**Consultation Response from KC,
Lead Local Flood Authority**
2021/90800 Hinchliffe Mill, Water Street, Holmbridge, Holmfirth, HD9 2NX
Redevelopment and change of use of former mill site to form 19 residential units (within a Conservation Area)
Date Responded: 17/10/2022
Responding Officer: Martin Stephenson
Responding Ref: 1
Previous responses by the LLFA

Documents reviewed by the LLFA:

Drawing Number	Revision
G560-CHG-XX-00-DR-C-0001	P5

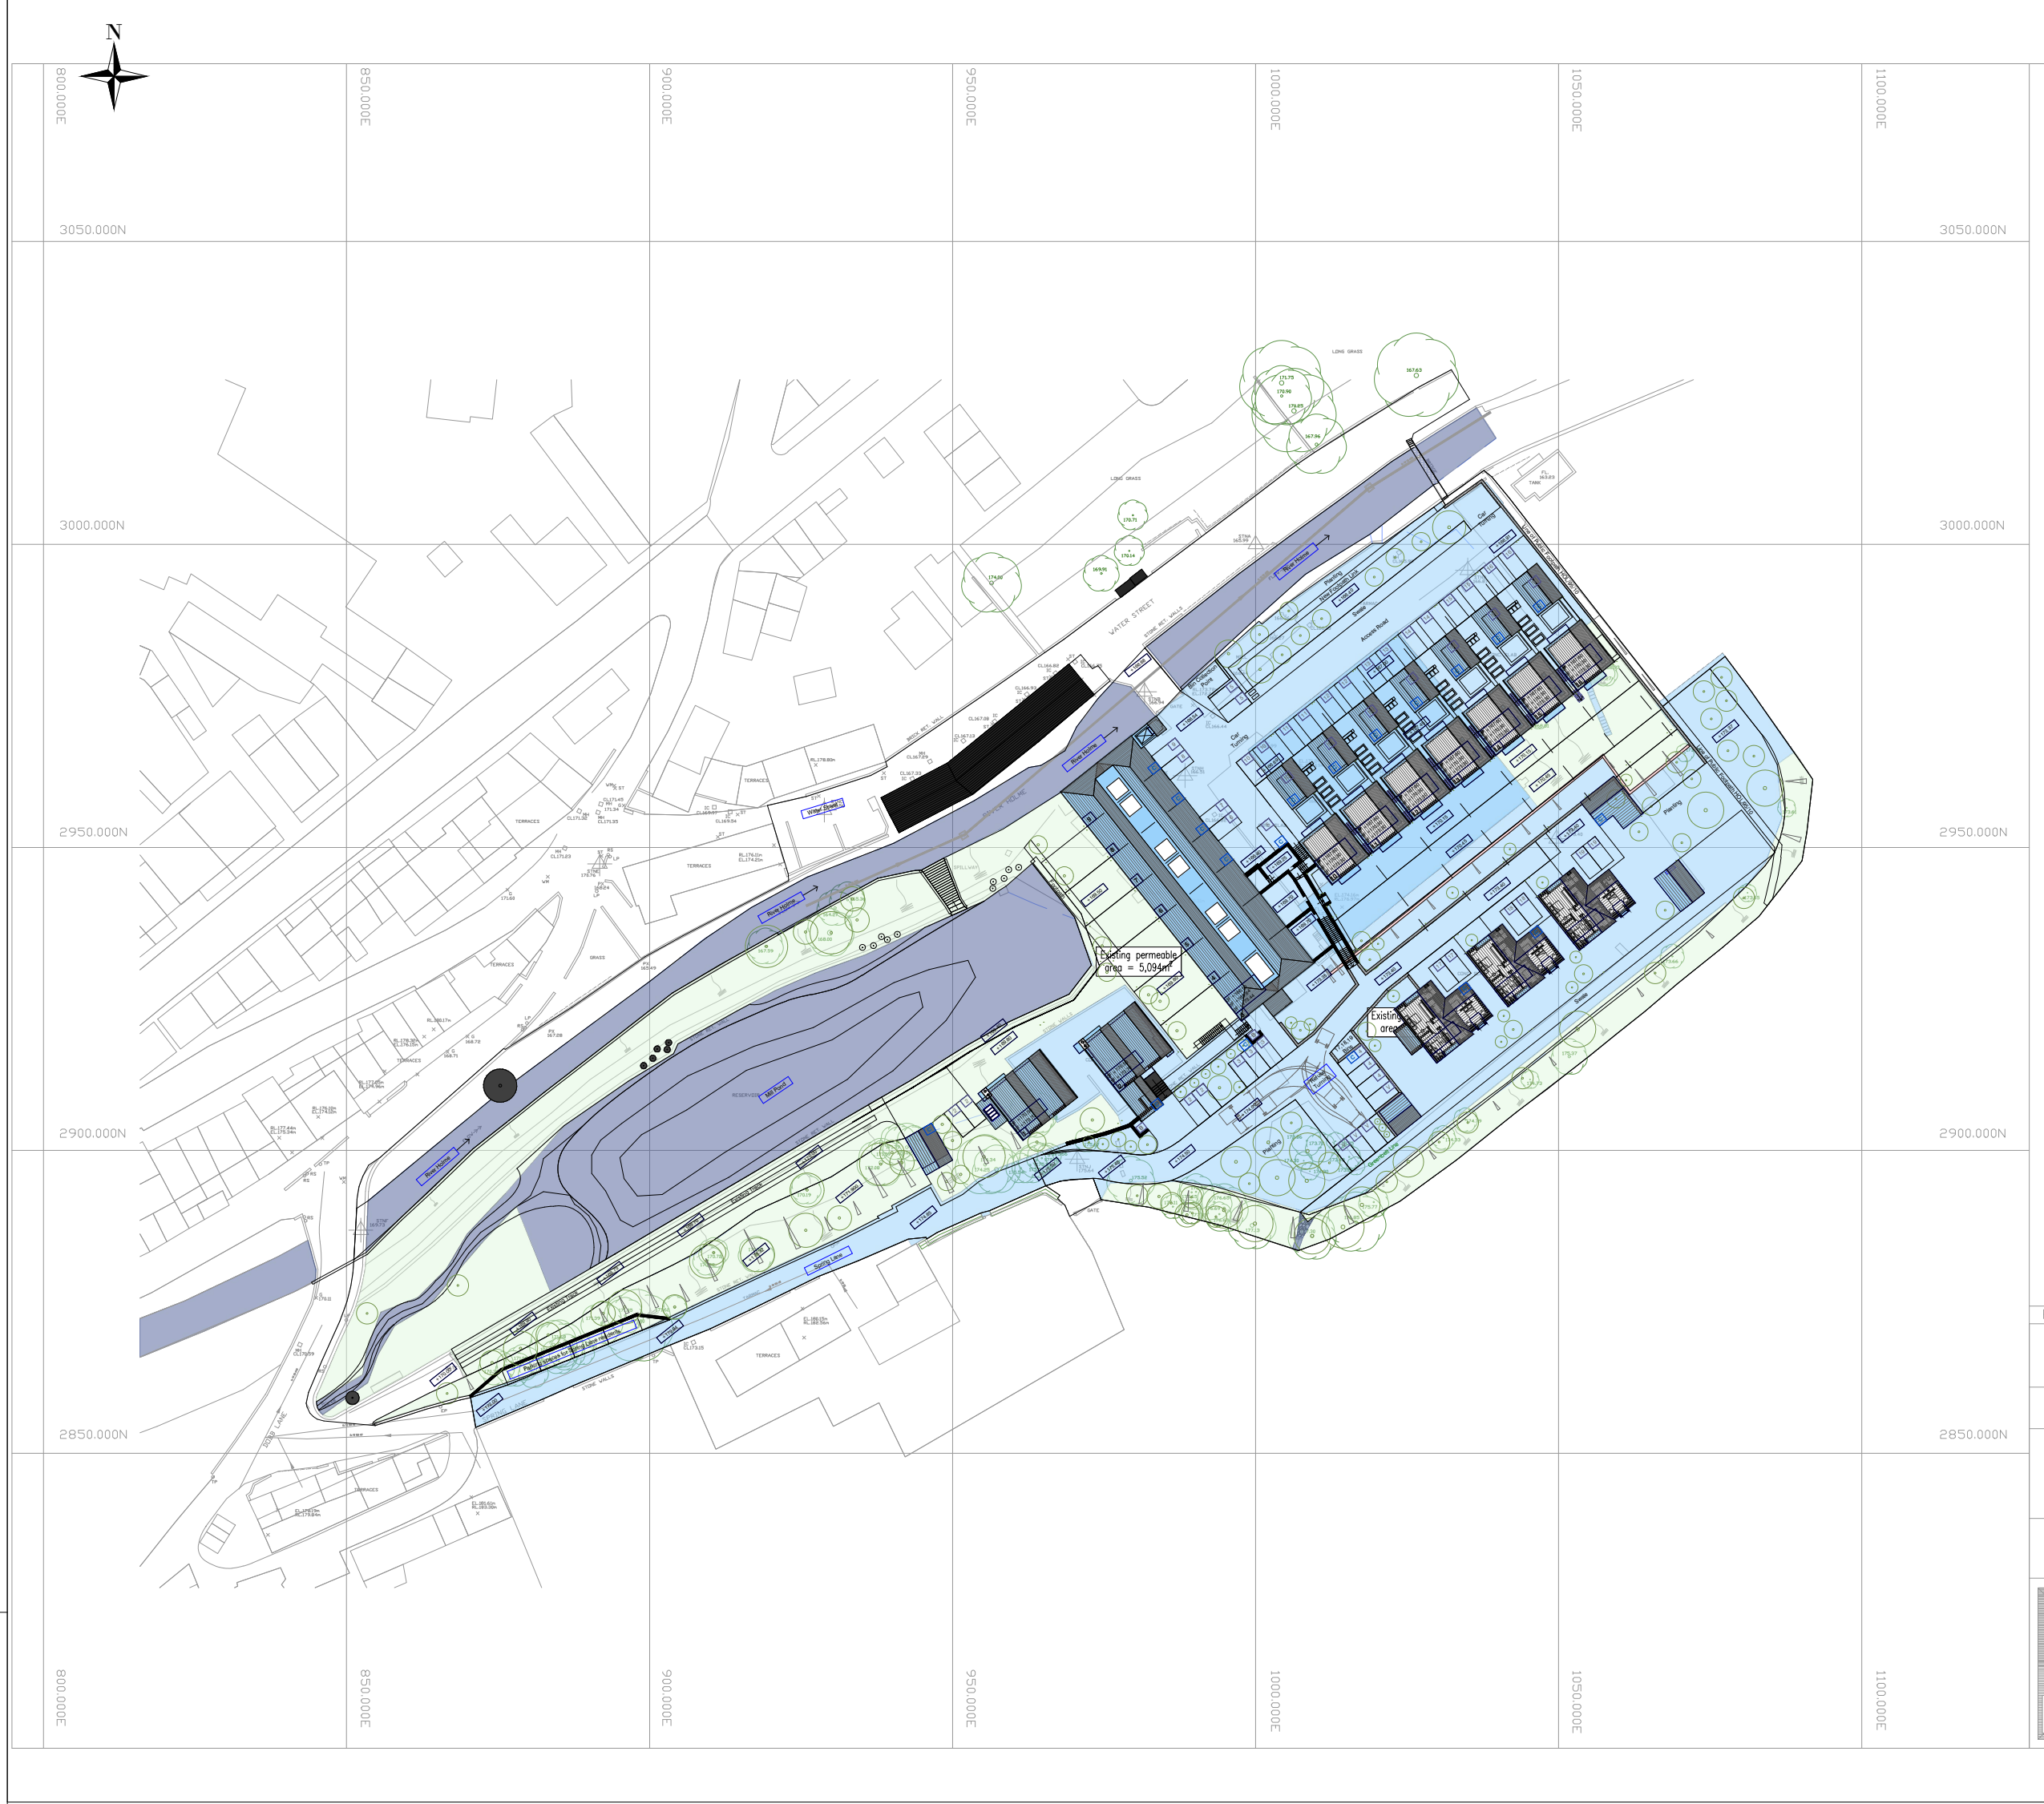
The LLFA confirms that the proposed attenuated surface water discharges of **3.0 l/s** to the mill pond and of **50.5 l/s** to the river are accepted as indicated on the Proposed Drainage Layouts (Revs P05/P06). Flows from the roof of the existing mill and the land drainage from the swale on the southern boundary can discharge to the river unattenuated.

The further investigation works should be undertaken as detailed in Section 4 of the Drainage Strategy, Rev 1.5 regarding soakage testing (in line with BRE365 guidance) and CCTV surveys of the existing surface water drainage to be retained and any repairs identified in the CCTV survey are to be carried out.
